Our Ref: AW/35/21/HH

**Application for Planning Permission for Works or Extension to a Dwelling**

**Development:** To extend ground floor by 2.5m across back of house. Knock three rooms at the back of the house into one including extension. To make a kitchen dinner. Change roof from a point to a Apex on both sides of the roof. Having a flat roof at the very top. Not going above existing height. Creating two bedrooms with master bedroom with a ensuite. A family bathroom and a small study. Dormer over rear bedrooms sloped to put solar panels on. Apex dormer over front study window. Old kitchen to be made into a utility and shower room with toilet. Existing living room to have a log burner in. Windows and doors to all be tripple glazed. Take gas out and replace with electric heating solar panels and air source heat pump.

**Location:** 27 Grosvenor Gardens Aldwick PO21 3EZ

Existing floor plan

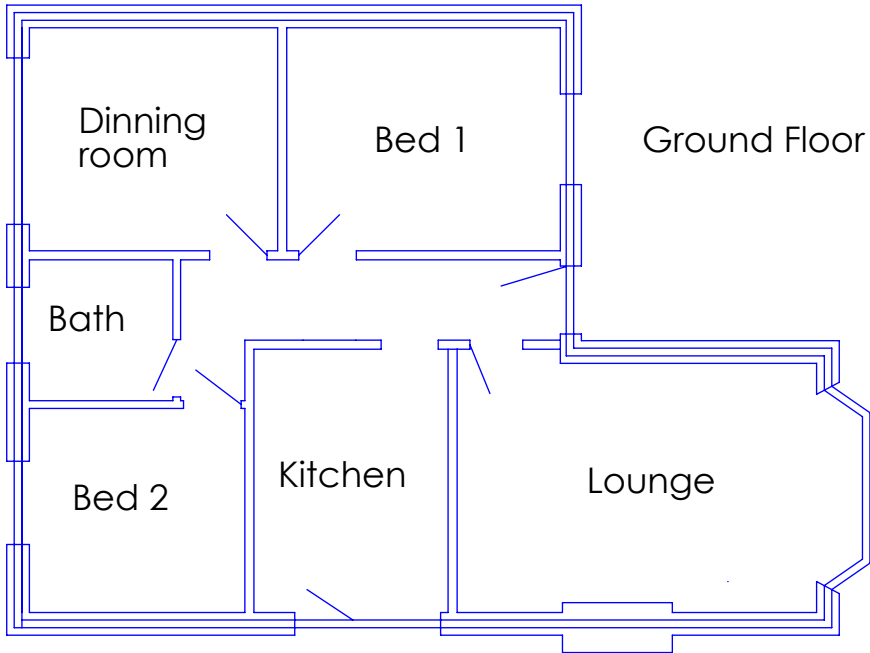
Existing Plans: Please provide the existing plans for this application

Site plan

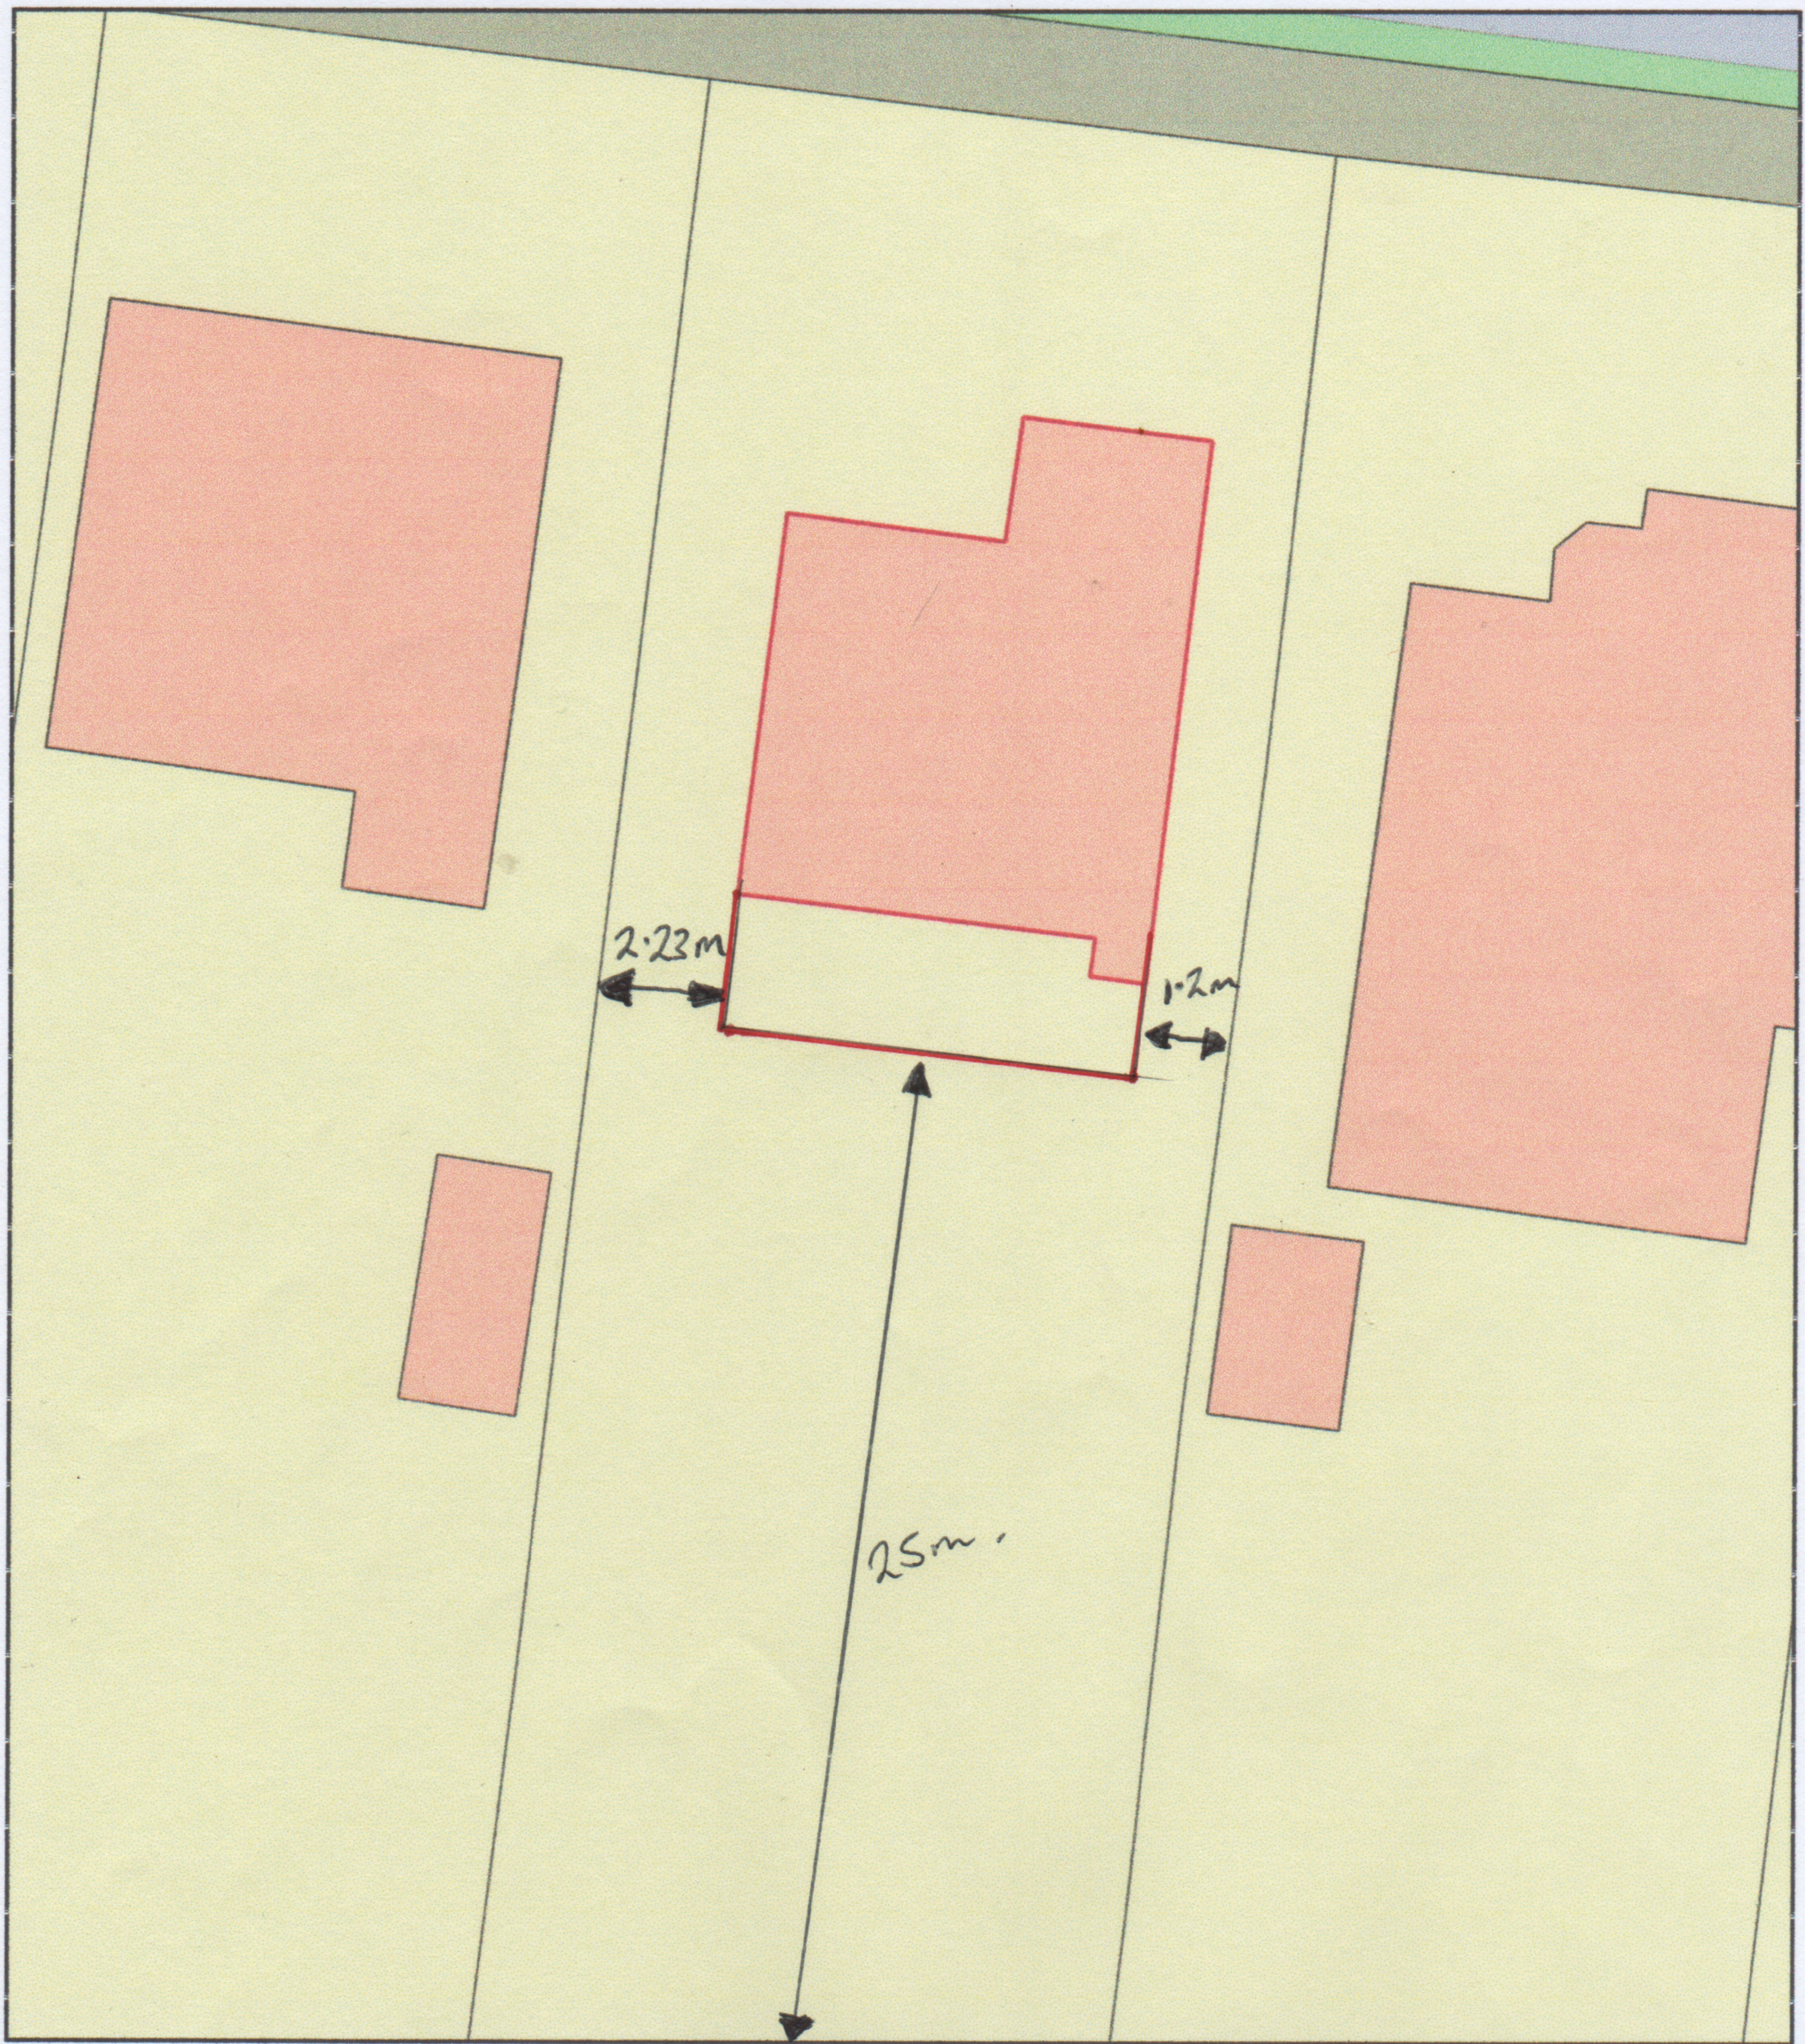
Location Plan: Please confirm the red outline is around the entire site

Dimensions: You are required to include dimensions on the block plan from the proposed extension to all site boundaries.
